**Consultation Response from KC,  
Trees**

**2021/93621 Land off, Fullwood Drive, Golcar, Huddersfield, HD7 4JH**

**Erection of 10 dwellings and associated works (Within a Conservation Area)**

**Date Responded: 03/11/21**

Description: PROPOSED SITE PLAN & 3D VIEW

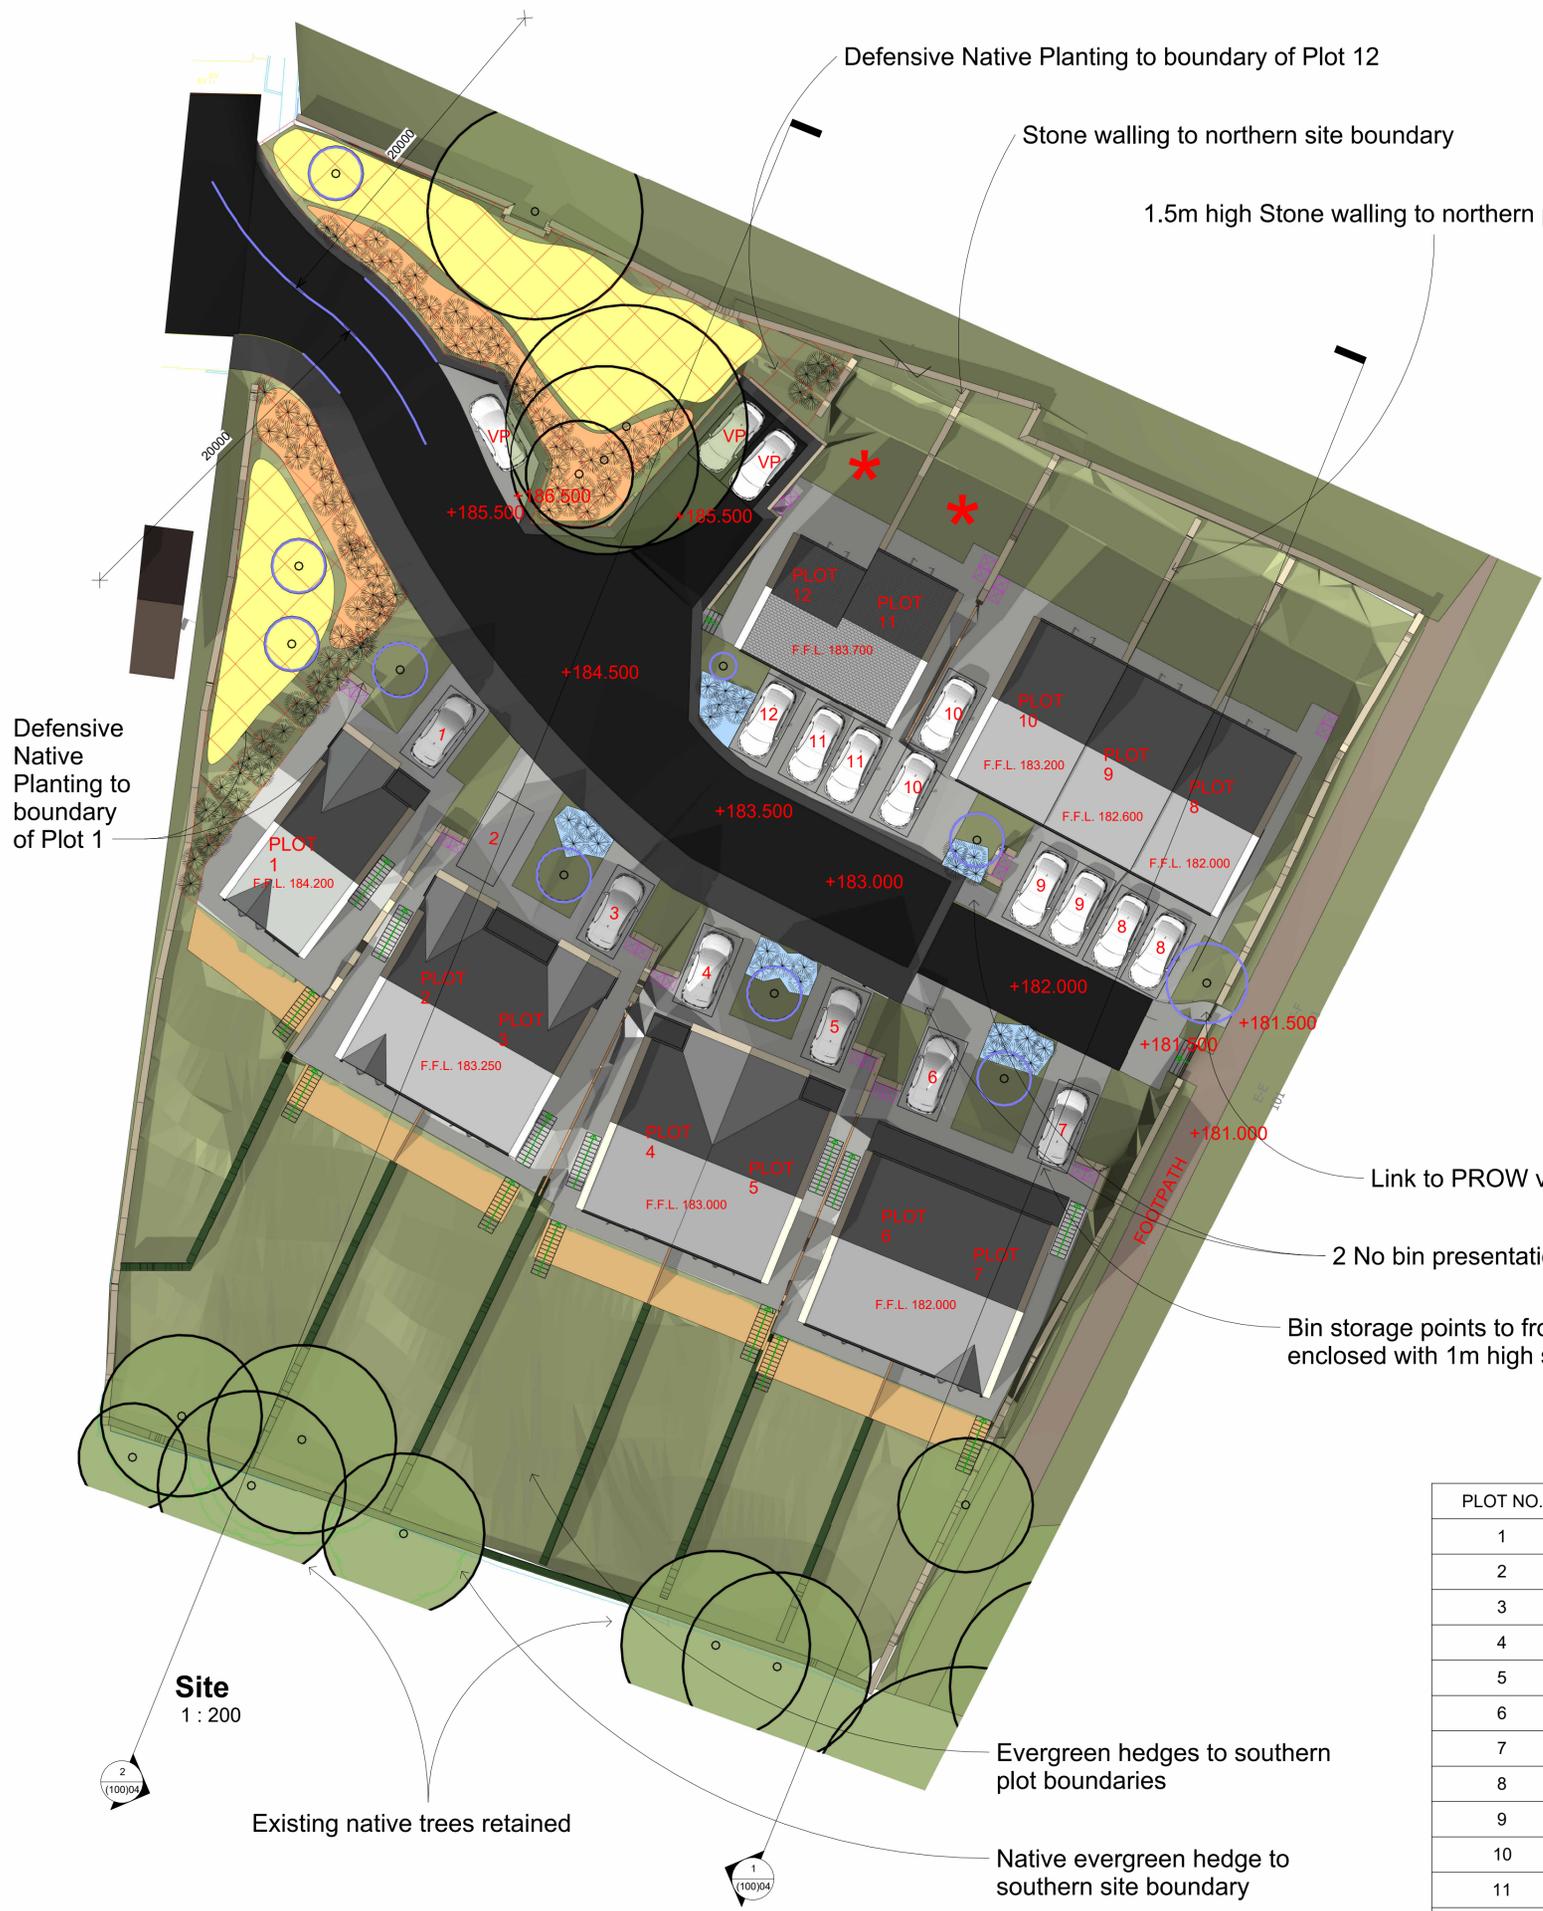
The proposed layout would require the loss of trees internal to the site with the exception of a few trees near the access and around the edge. The proposals require significant level changes to create a level developable area. This would have an impact on any trees along the eastern boundary of the site. It isn't clear what trees are to be retained let alone an assessment of the impact of removing trees.

The proposals do not appear to meet Kirklees local plan policy LP24i and PL33. Trees of significant public amenity are likely to be removed to facilitate the development which would result in a negative impact on the character of the Golcar Conservation Area.
